SCOPING OPINION:

Proposed Hampshire Water Transfer & Water Recycling Project

Case Reference: WA010002

31 August 2023

Drawing Number  
 710166-SWS-XX-XX-DR-Z-00

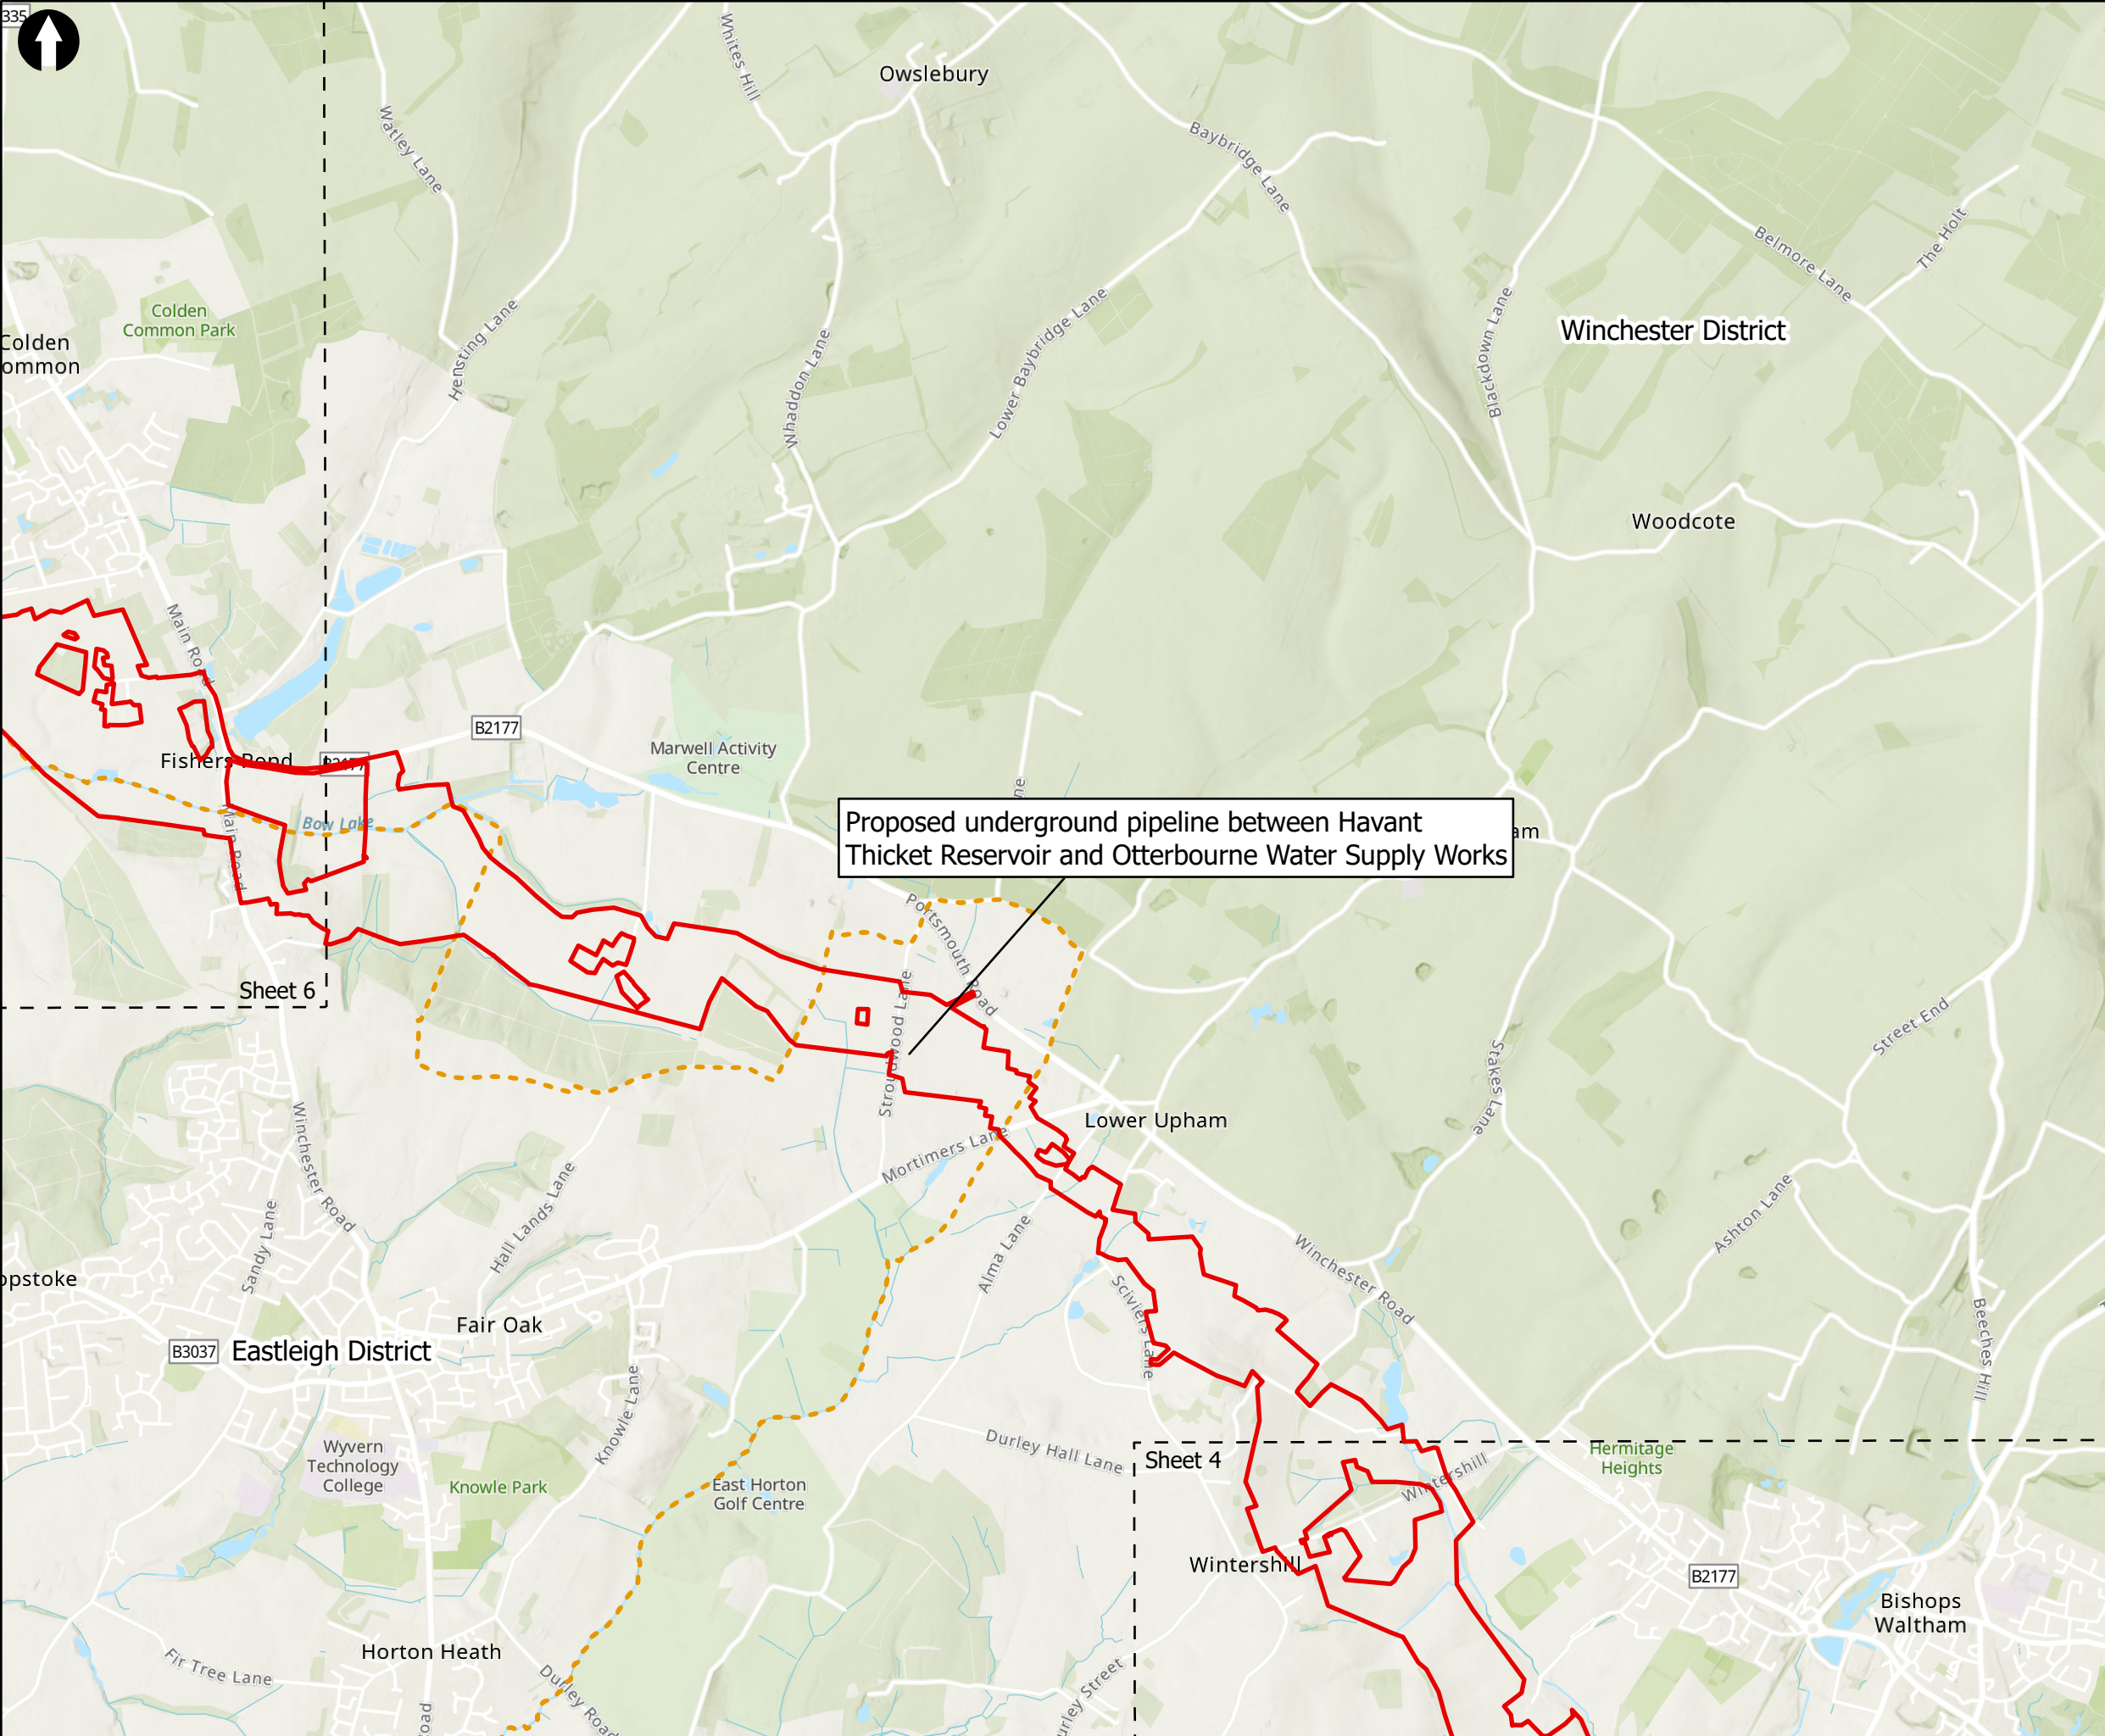
2.2.2	Chapter 4	Order limits	<p>The scoping area shown on Figures 1.1 and 1.2 is proposed to be refined further through scheme development and EIA processes prior to confirmation of the Order limits within the DCO application. The ES should include an explanation of any changes made following scoping,</p>

ID	Ref	Description	Inspectorate's comments
			including how environmental effects have been considered in finalising the Order limits.
2.2.3	Chapter 4	Alternatives	Paragraph 4.1.4 of the Scoping Report references a separate document, Scheme Development Summary, from the Applicant's consultation in summer 2022, which provides further detail about alternatives assessed during the development of the project. The Inspectorate considers that this document should be submitted as part of the ES, eg as a technical appendix, together with any other relevant documentation that has been used to inform the consideration of alternatives through the Regulator's Alliance for Progressing Infrastructure Development (RAPID) gated process.
